Project Name: Accessory Studio building  
Project ID: #2016-257  
Address: 11 Ocean Street, Peaks Island CBL: 090 B003001  
Applicant: Jeffrey D Clements  
Planner: Jean Fraser

On January 9, 2017, the Planning Authority approved a Level I Site Alteration application to construct a new 440 sq ft accessory studio to replace the existing shed, located within the Shoreland Zone on the rear part of 11 Ocean Street, Peaks Island. The decision is based upon the application, documents and plans as submitted and prepared by Rachel Conly Design LLC.

The proposal was reviewed for conformance with the standards of Portland's site plan ordinance and the Shoreland Zone. The approval is based on the submitted site plan (Site Plan A2 dated 11.2.2016) and subject to the following conditions:

A2

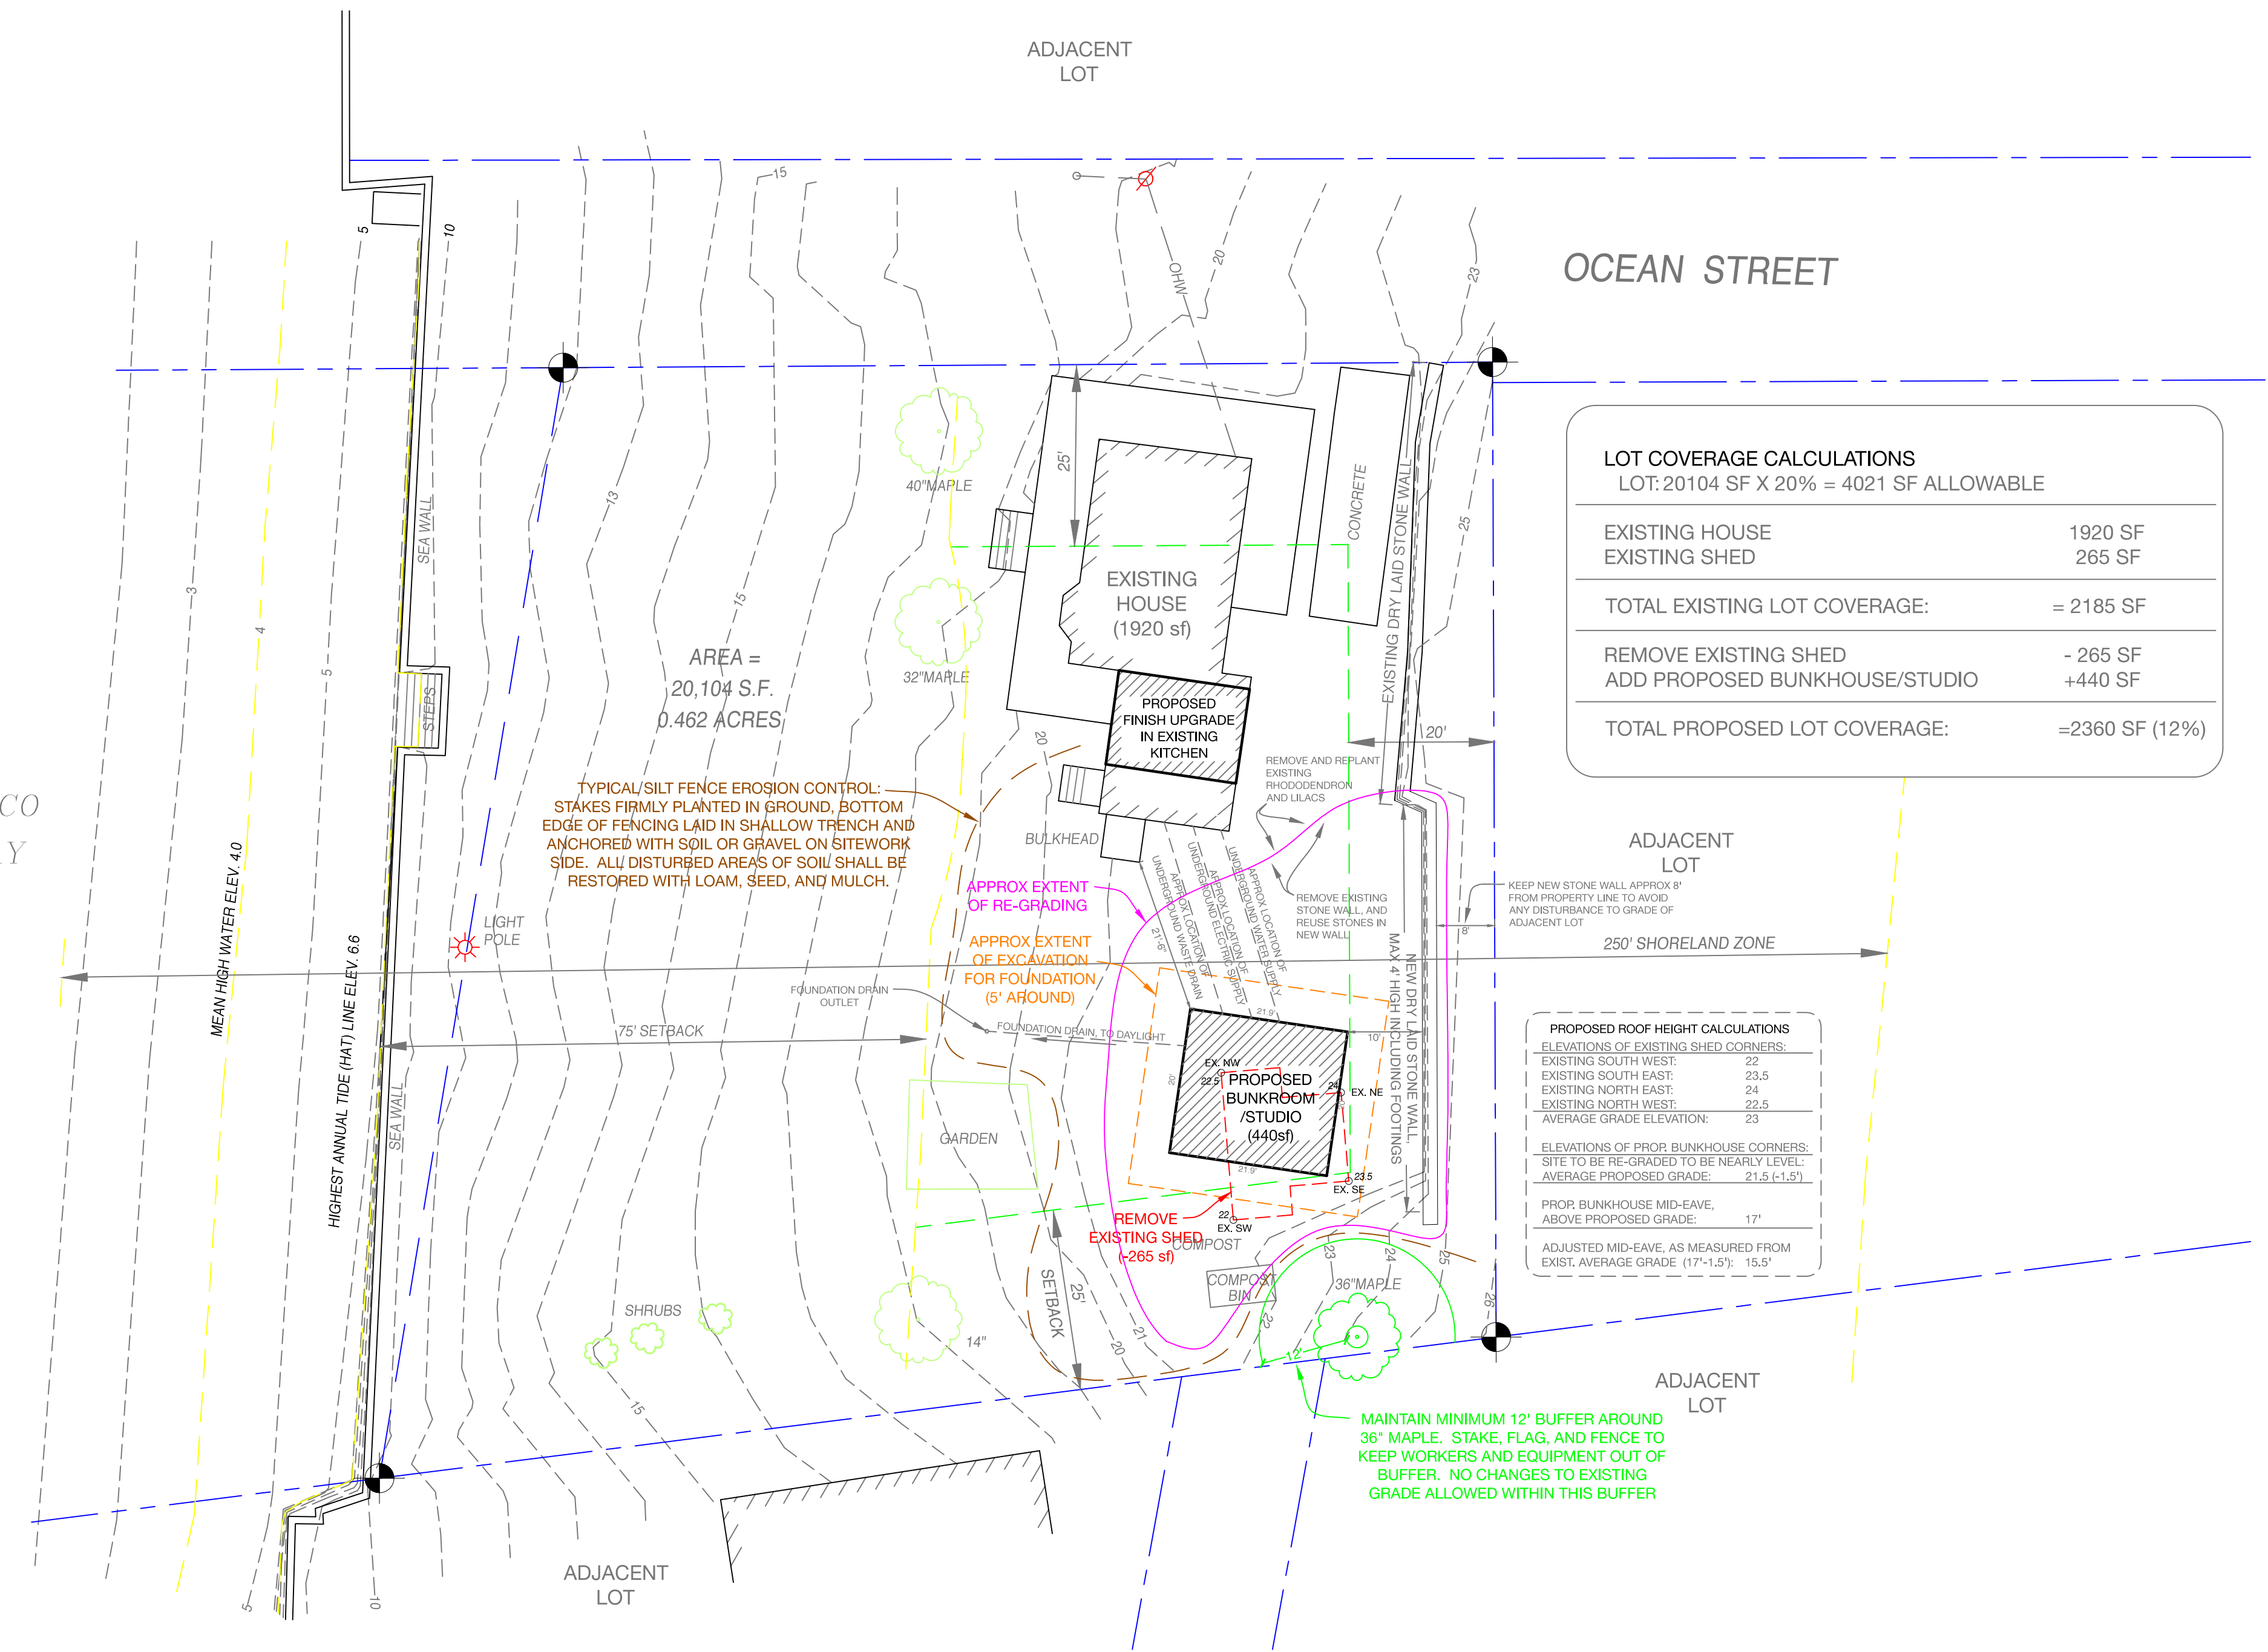
1. That the project does not add fill nor grade near the root zone of the large tree at the back corner of the lot, as filling and grading would likely stress the tree and impact its growth. Grading within the drip line of the tree should be minimal and care should be taken to protect the tree from grading or other construction impacts.
2. That all Site Work shall conform to the City of Portland ordinance on Shoreland Regulations (Division 26).
3. That Erosion and Sedimentation control shall be established and inspected by the Development Review Coordinator prior to soil disturbance, and shall be done in accordance with Best Management Practices, Maine Department of Environmental Protection Technical and Design Standards and Guidelines. All Erosion and Sedimentation control measures must be inspected and maintained daily.
